APPLICATION NO 2020/94418

Dear Sir or Madam I am writing
to protest the planning application
for 21 Hill Grove Lea
Salendine Wook Huddersfield
HD3 3YD I am not happy so I am
objecting to a building line with
over hanging of Roof encroaching
already I am faced with a mass of
blank wall Grabbing face The wall
sits on the boundary line so the
roof will over hang which will have
more bulk and also will have to
come on to my property to do the
maintainence work I have had a
word with Mr Meers and he
understands the problem so he
is going to have a word with the

Side Elevation S  
1 : 100

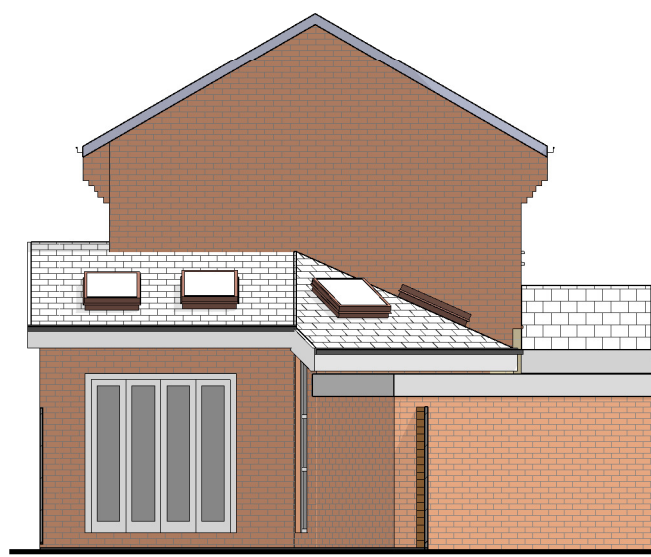
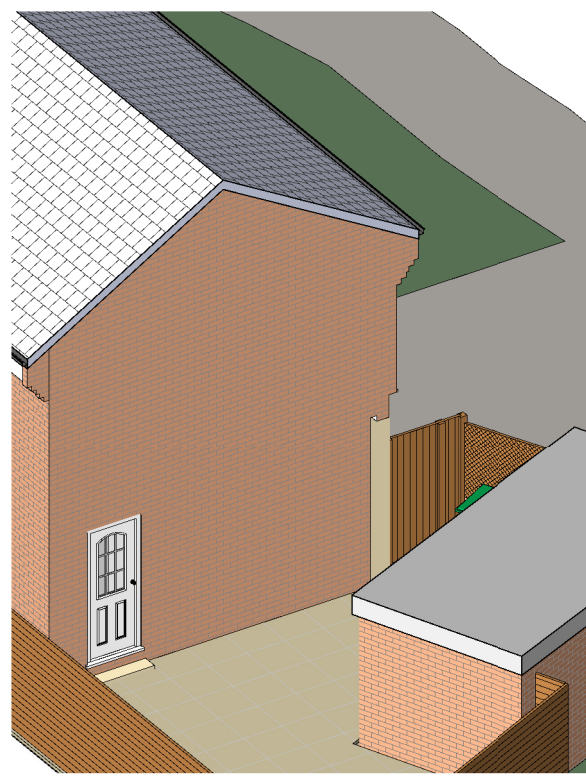
architect then he will come back
with a proposal they are going
to keep in ~~best~~ touch with you
So please can you let me know
if they come up with any new
plans and send me a copy I would
be very grateful
